CITY OF ALBUQUERQUE

December 24, 2018

**Re: Mesa Del Sol Unit 3B
Erosion Sediment Control Plan
Engineer's Stamp Date 12-19-18 (R16E006)**

TEMPORARY EROSION AND SEDIMENT CONTROL PLAN

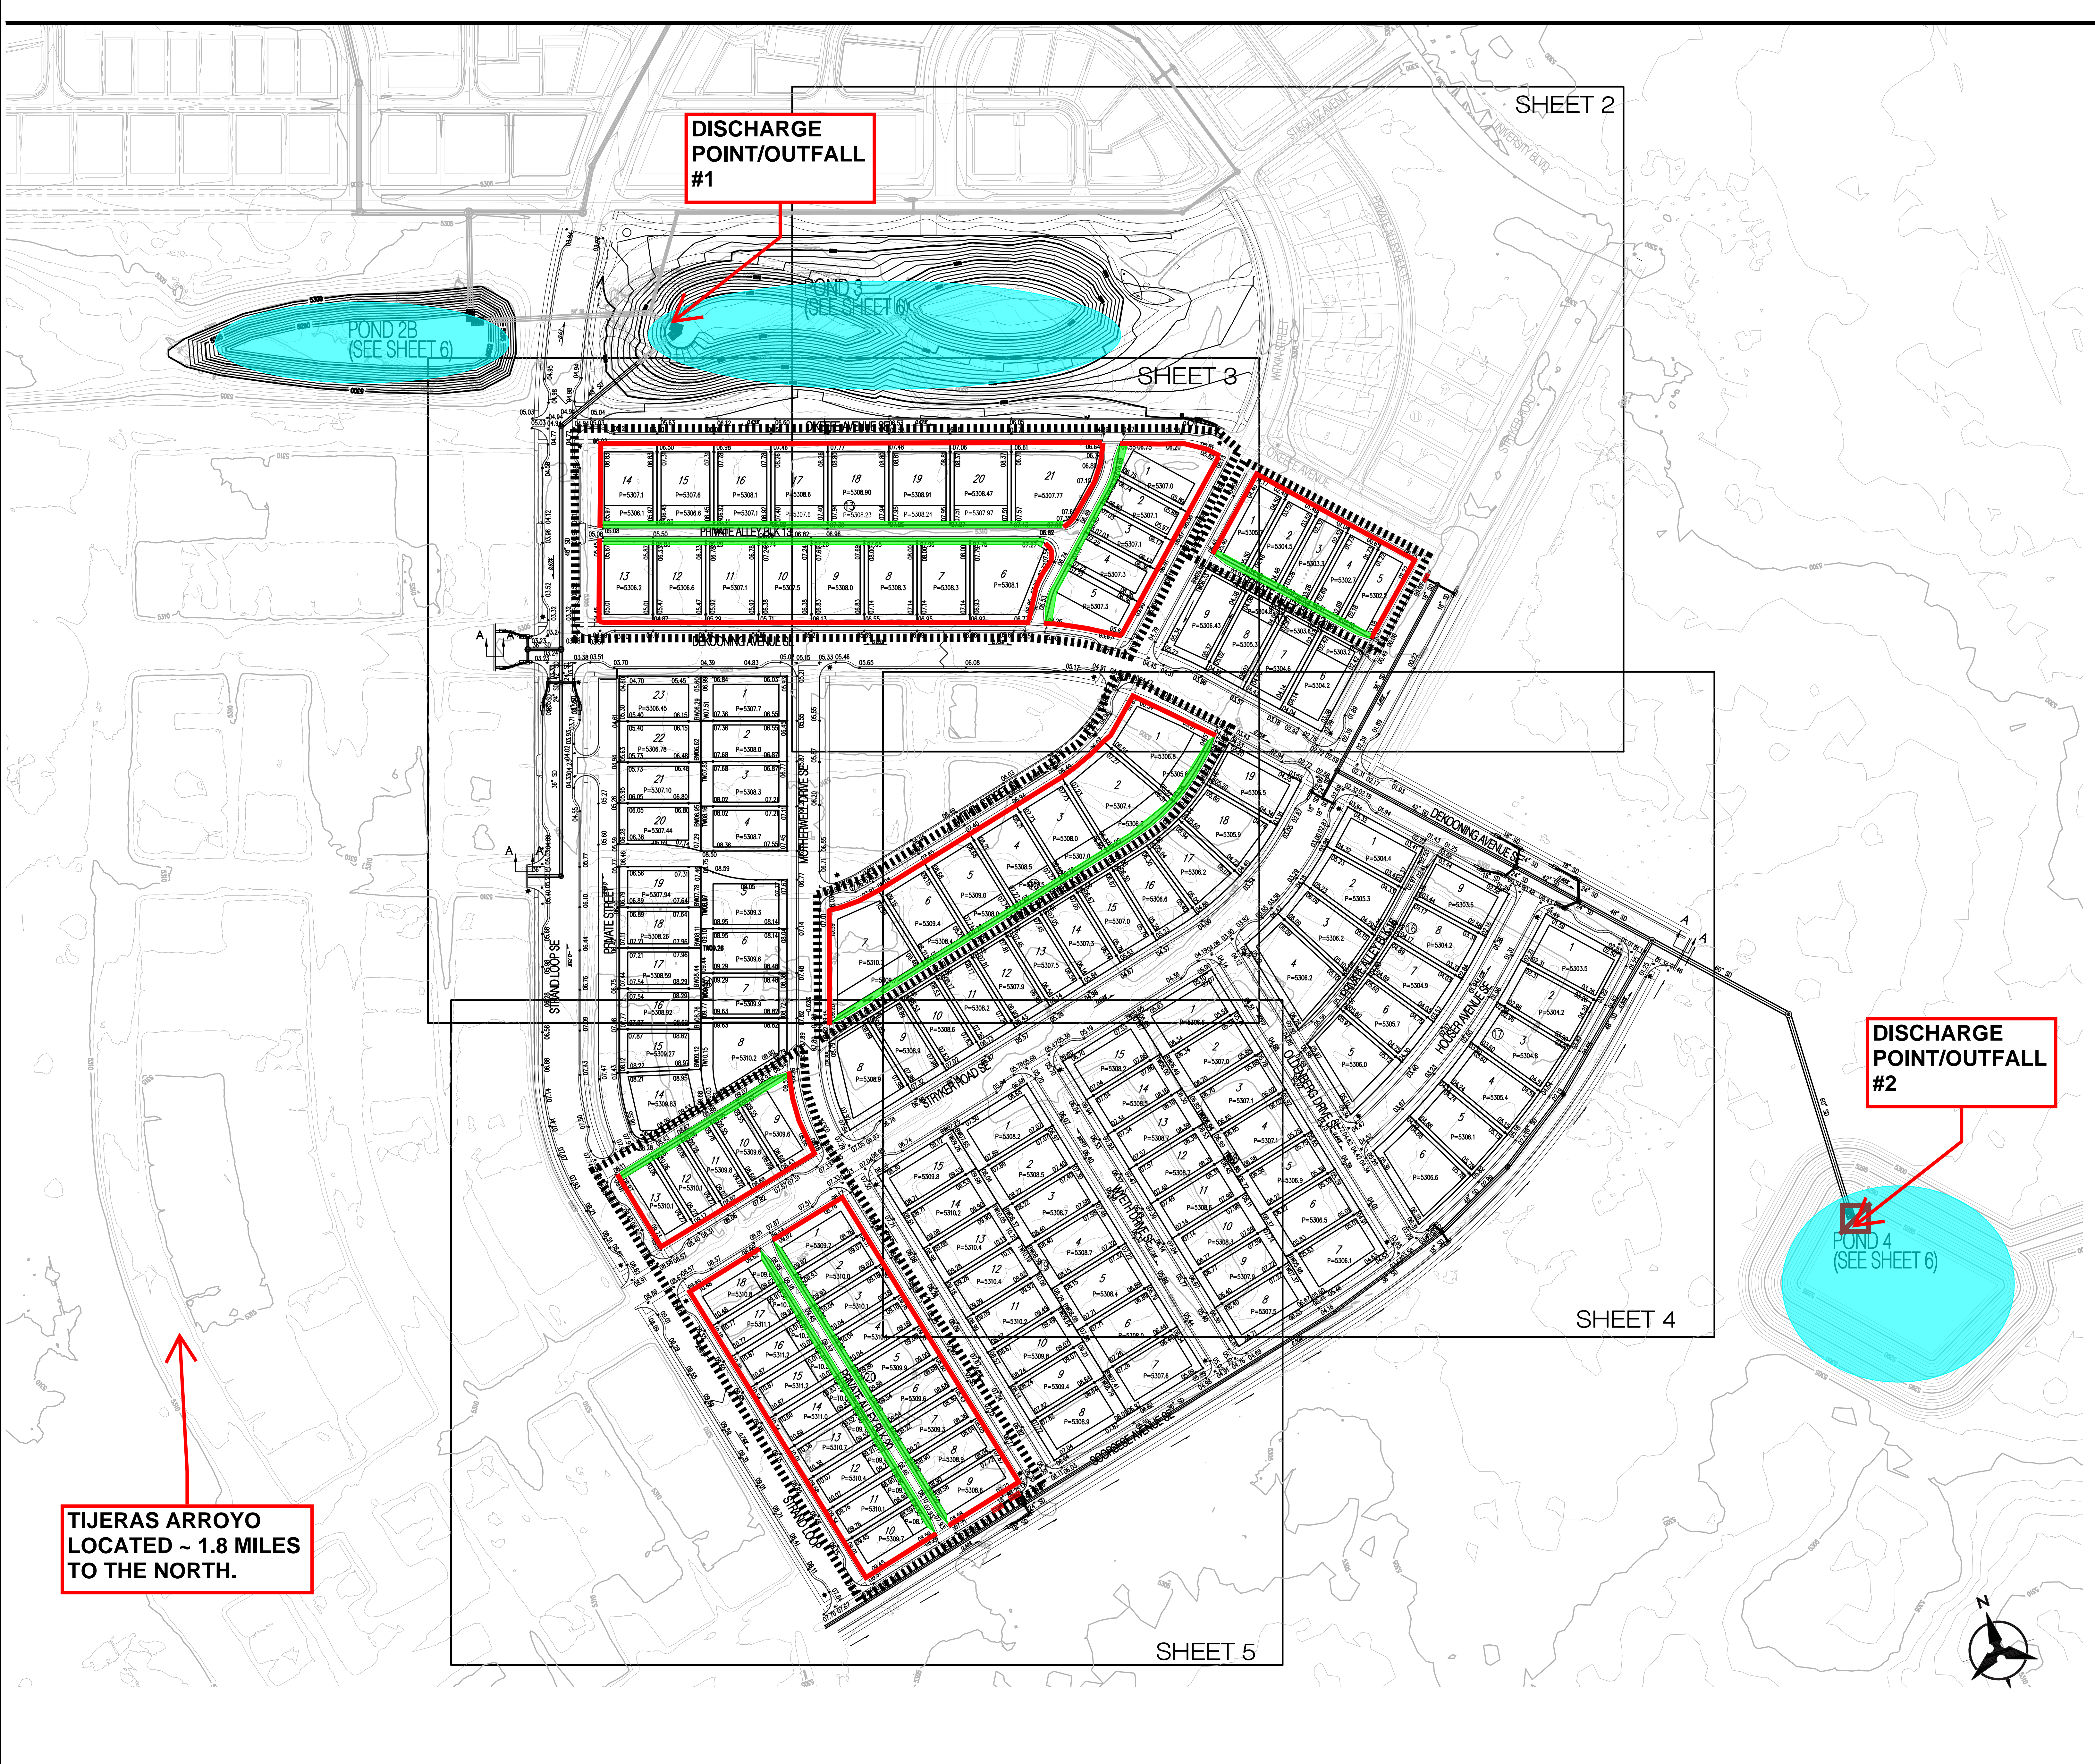
1. Provide existing and proposed grades. The best way to accomplish this may be to superimpose the BMPs on the grading plan.
2. Show all areas of disturbance.
